Windermere Zone Change
Traffic Impact Study
PCD File No.: P229 & SP223
(LSC #S224091)
January 25, 2024

RE: Windermere Zone Change
El Paso County, CO
Traffic Impact Study
PCD File No.: [P229](#) & [SP223](#)
LSC #S224091

Figure 9  
**Short-Term Total Traffic, Lane Geometry, Traffic Control and Levels of Service**  
 Windermere Zone Change (LSC #S224091)

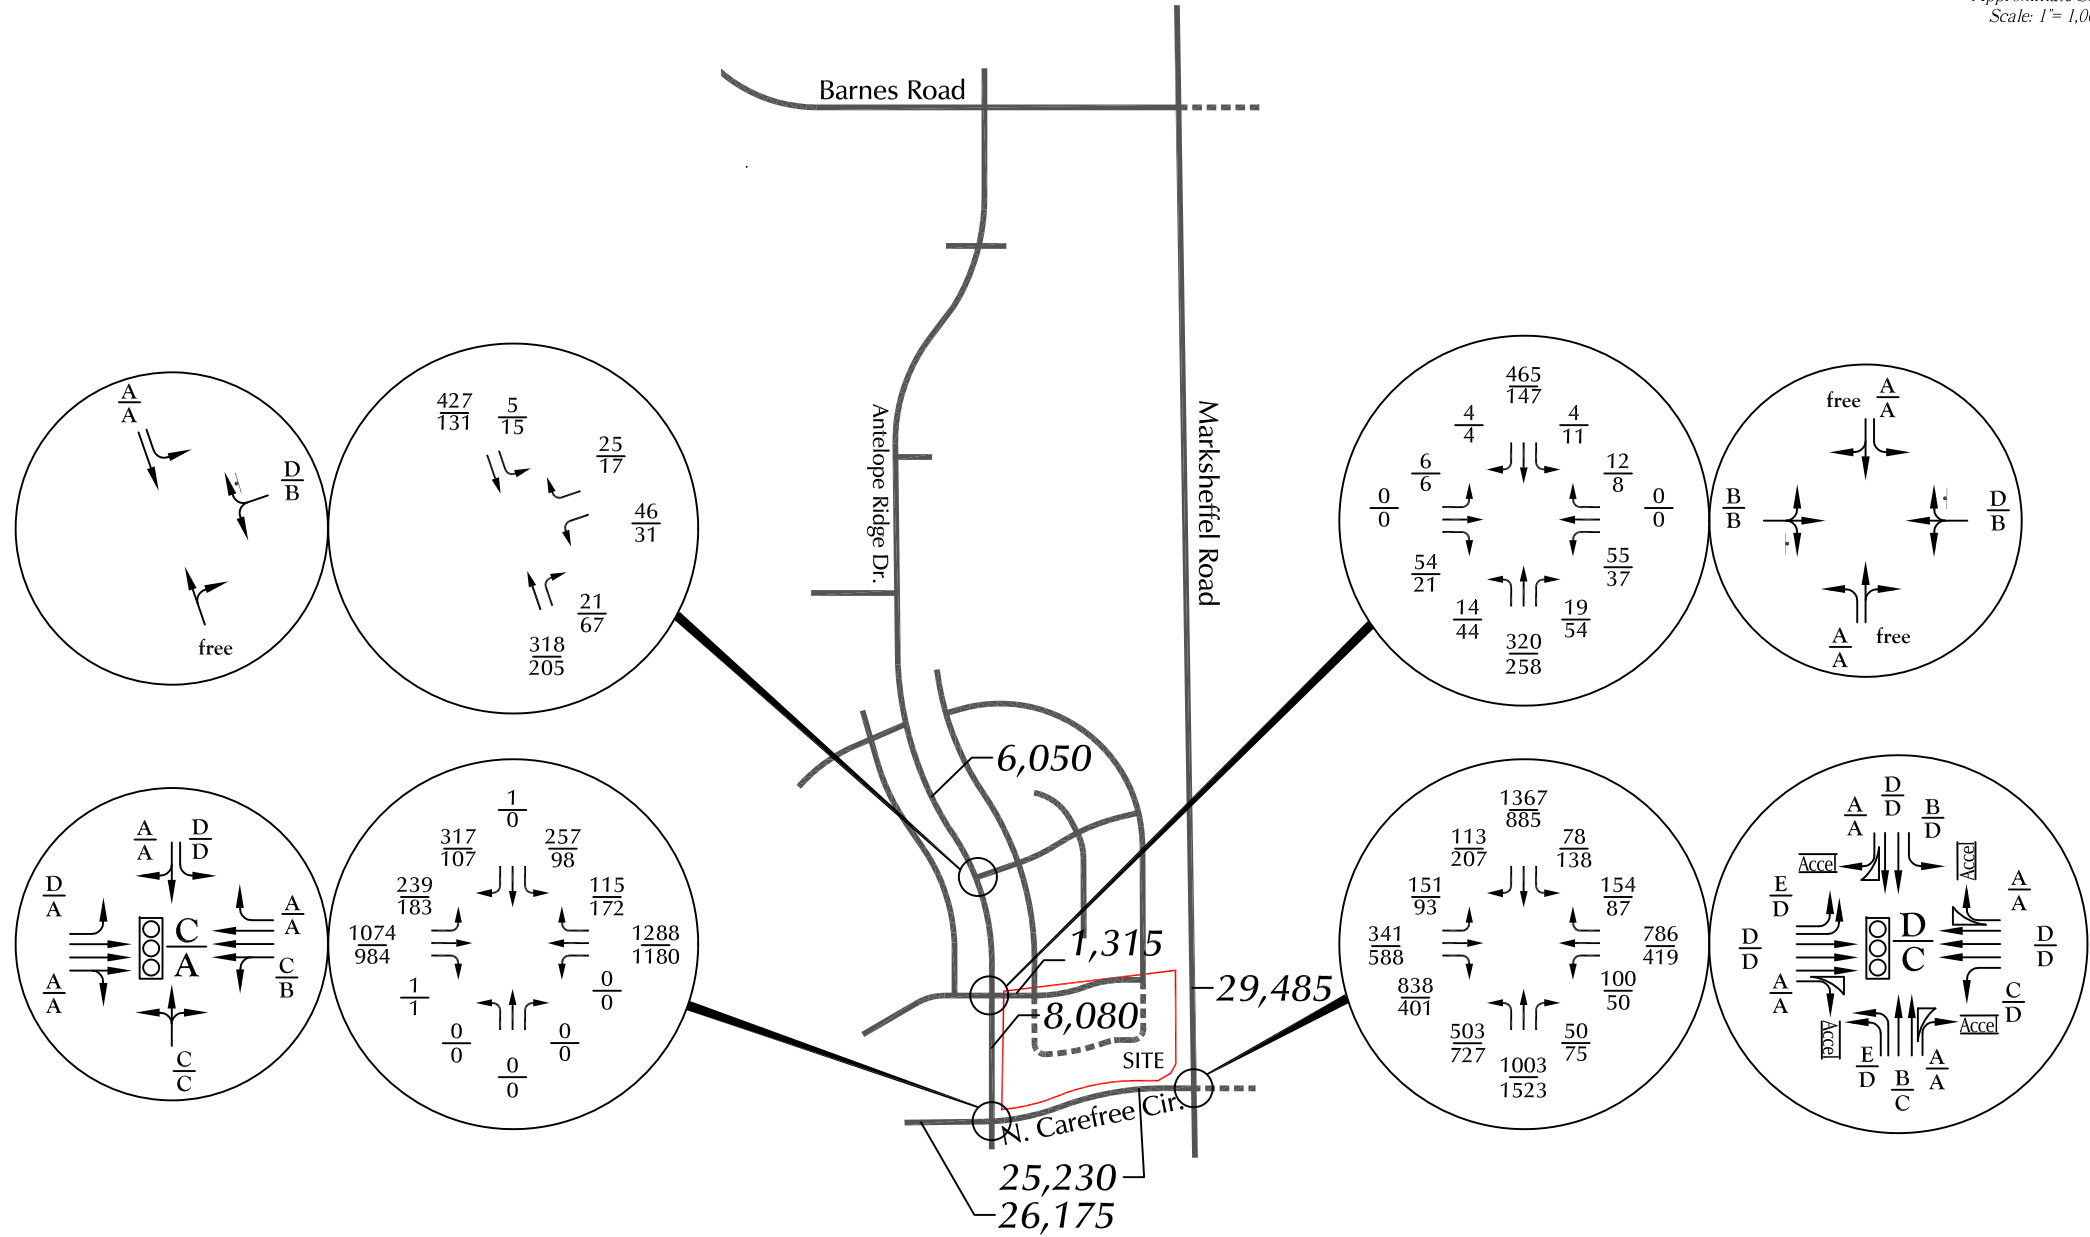
Please indicate year of short-term.

Please include excerpt of this study. Please highlight the total traffic of short term.
